WEST SUSSEX COUNTY COUNCIL CONSULTATION

TO:	Arun District Council FAO: Andrew Wood
FROM:	Highways, WSCC
DATE:	03/01/2019
LOCATION:	20, Lashmar Road, East Preston, Littlehampton, BN16 1EY
SUBJECT:	EP/182/18/PL 1 No. end of terrace house together with associated car parking, new vehicular access, garden shed & planting (resubmission following EP/148/17/PL).
DATE OF SITE VISIT:	N/A
RECOMMENDATION:	☒ Advice ☐ Objection ☐ Modification ☐ No Objection ☐ More Information ☐ Refusal
S106 CONTRIBUTION TOTAL:	£N/A

SITE PLAN

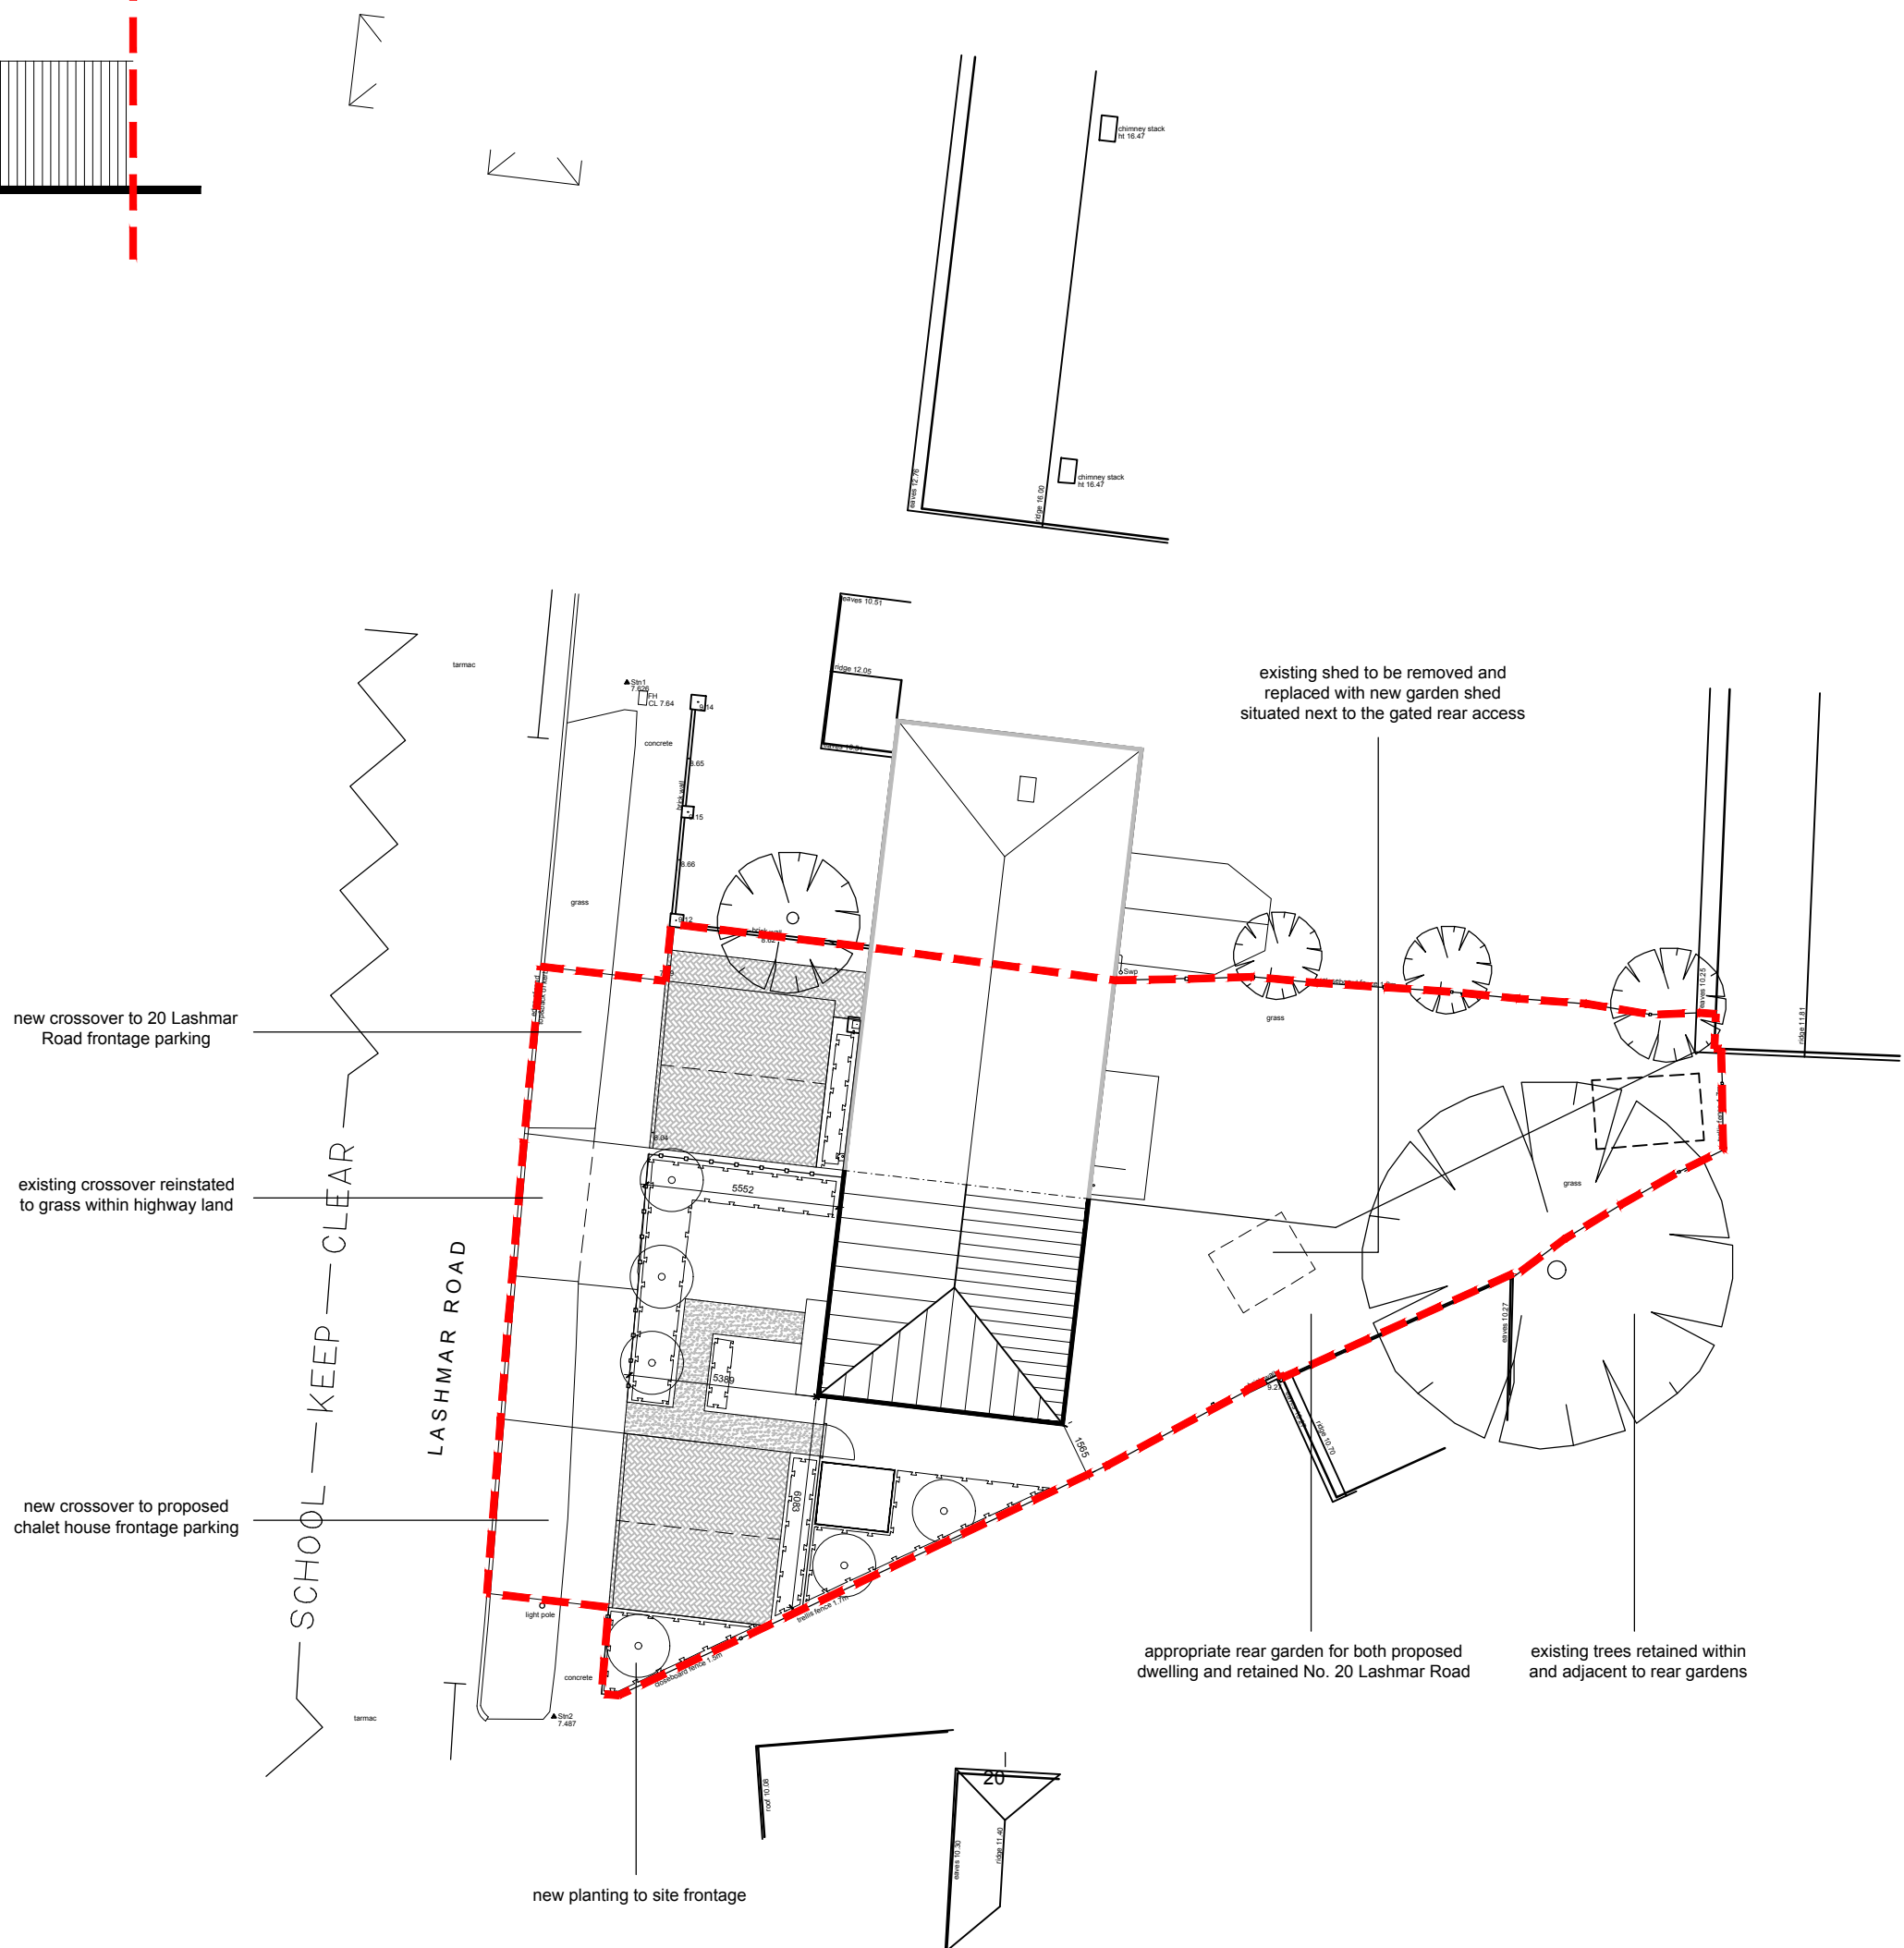
An inspection of the Design and Access Statement and site plan establishes that a new vehicle crossover (VCO) is proposed to provide access to the off-street parking spaces serving the new dwelling. A study of local mapping demonstrates that it is likely that the crossover works will require the relocation of the street-lighting pole located on publicly maintained highway fronting the application site. These relocation works would need to be undertaken at the expense of the applicant. It is the responsibility of the applicant to liaise with the necessary parties to organise the moving of the street-lighting pole. The pole will need to be relocated at least 1.5m from the location of the top of the ramped kerb of the proposed crossover.

The Design and Access Statement confirms that the existing VCO serving no. 20 Lashmar Road is to be closed off and a new VCO created to serve the revised parking arrangements at this address. The two new proposed VCOs must be implemented under licence to a specification obtained from WSCC Highways.

A study of the online documents and plan establishes that 2 off-street parking spaces will be provided for the new dwelling. This is in accordance with the WSCC Parking Demand Calculator. The existing parking arrangements serving no. 20 will be re-configured to allow for 2 cars to park off-street on the property's frontage. The current access serving the existing driveway will be closed off.

A turn on-site would be preferred; clearly though there is insufficient space to achieve this. However, other properties have similar arrangements and balanced against this is the benefit of providing an opportunity to remove vehicles that would otherwise be parked on the highway in a location where the existing practice is on-street parking by residents which results in a noticeable narrowing of the existing available carriageway space.

The site is in a sustainable location, within walking distance along street-lit footways of a range of local shops and other amenities. Nearby bus stops along North Lane provide good links on to larger towns and cities further afield and Angmering train station is within 0.7 mile. It is noted that cycle storage is to be provided as part of the proposal, promoting further alternative modes of sustainable transport. The plans indicate that this will be covered and secured and of sufficient size to serve the development.

No part of the development shall be first occupied until such time as the existing vehicular access onto Lashmar Road has been physically closed in accordance with the approved plans.

No part of the development shall be first occupied until such time as the vehicular accesses serving the new dwelling and the new parking arrangements at no. 20 Lashmar Road have been constructed in accordance with the approved drawing.

No part of the development shall be first occupied until the car parking spaces have been constructed in accordance with the approved site plan. These spaces shall thereafter be retained at all times for their designated purpose.

No part of the development shall be first occupied until covered and secure cycle parking spaces have been provided in accordance with the approved plan.

Street-lighting Pole - The applicant is advised to contact the operator of the street lighting pole to organise the moving/relocation works.
